Your Ref: EN010151
Our Ref: 23/0471/NSIP
Contact: Sylvia Bland
Email: [REDACTED]@n-kesteven.gov.uk

RE: Beacon Fen Energy Park DCO – Deadline 7 Submissions for North Kesteven District Council

ExQ3 BIO3.2 – NKDC’s comments on the updated Ecology Chapter (REP5-013/014)

PART OF  SLR

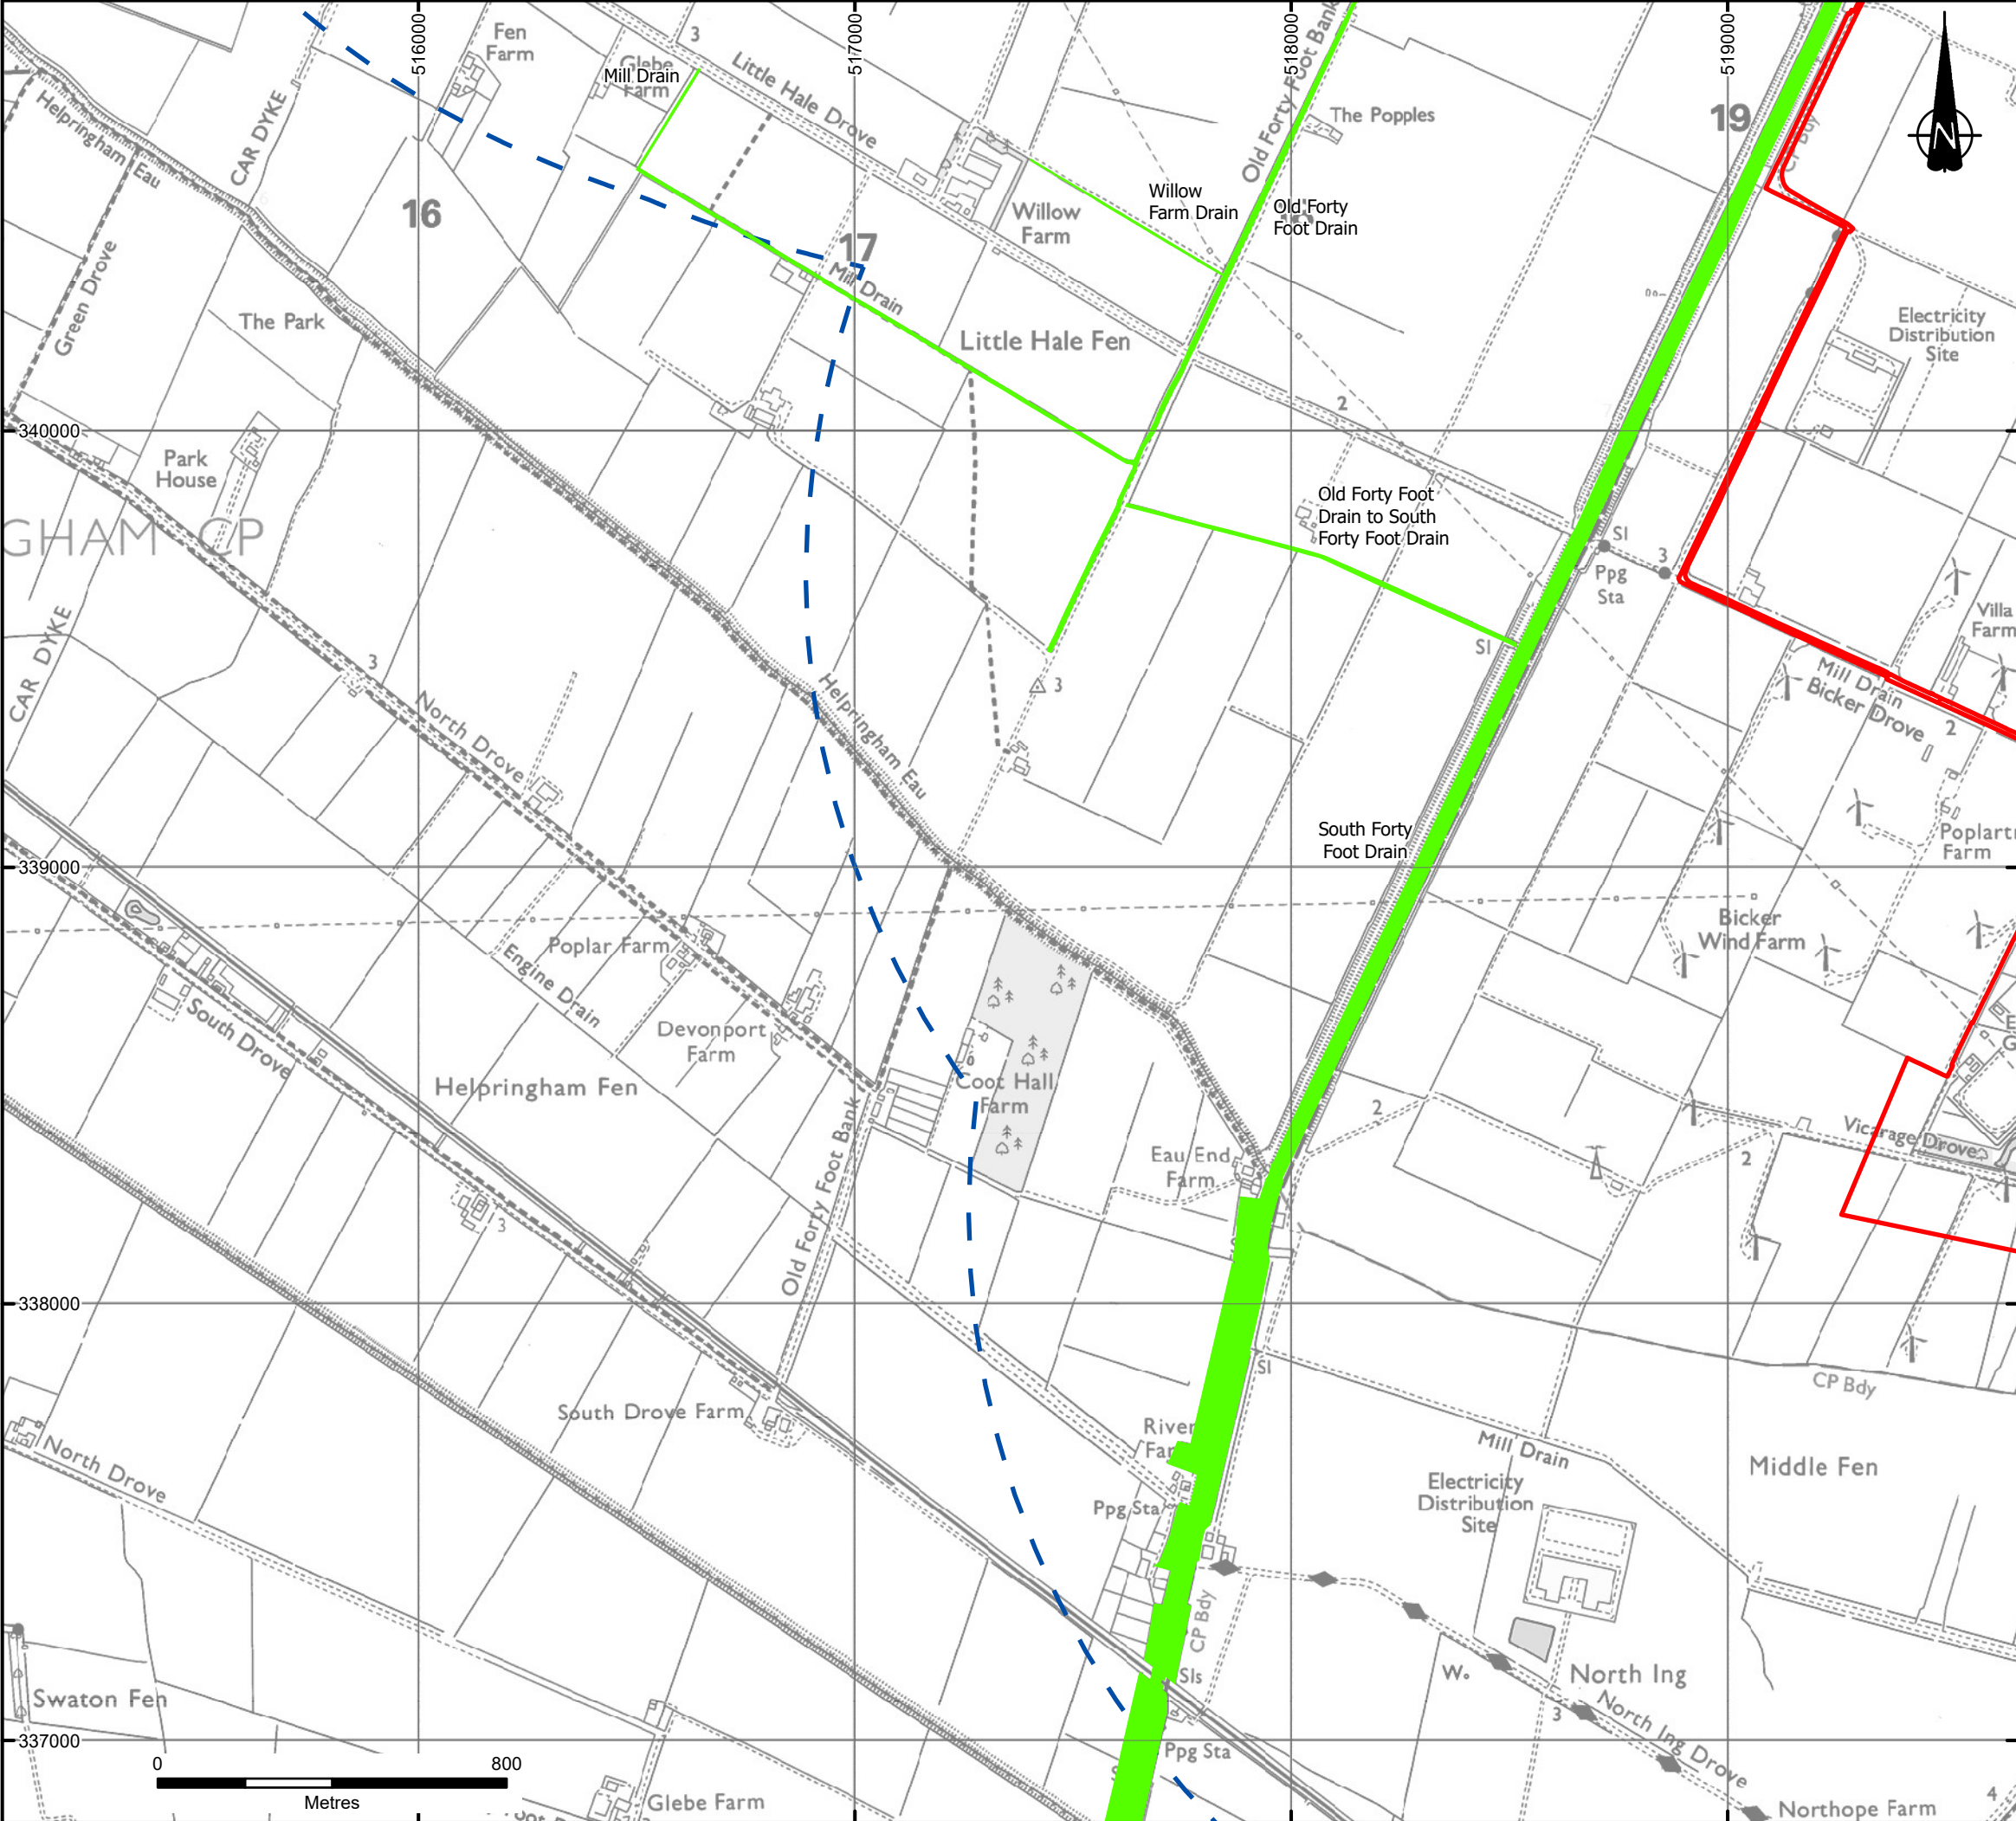
The impact on Great Hale Eau LWS seems to have been assessed without reference to specific baseline survey data (i.e. surveys relevant to the reasons for designation and aquatic habitats) and without a clear statement on the reasons for designation (this is not clearly identified elsewhere in the Chapter). There is also insufficient attention to whether this impact is avoidable, even though avoidance seems practicable (i.e. HDD, as committed elsewhere). Given this, there is an apparent conflict with Policy S60 of the Central Lincolnshire Local Plan.

This response overlooks the fact that a significant effect has been reported in relation to the Great Hale Eau LWS (paragraph 7.6.38 of REP5-014). It is irrelevant that the impact is subsequently mitigated to an acceptable level given the mitigation hierarchy needs to be addressed, as identified above, and this requires avoidance to be considered first.

- A new impact is identified in relation to Great Hale Eau LWS. As noted and discussed above, the applicant does not demonstrate a mitigation approach that responds to Policy S60 of the Central Lincolnshire Local Plan. It is not agreed that the mitigation hierarchy has been adequately applied. There are methods available to the Applicant that would avoid the impact (HDD or similar) and that are committed elsewhere for other watercourse crossings. The mitigation offered in Table 7.9 of REP5-013/014 focusses on restoration of bank habitats, but it is not clear this mitigation adequately responds to the reasons for designation as these are not clearly stated within REP5-013/014.
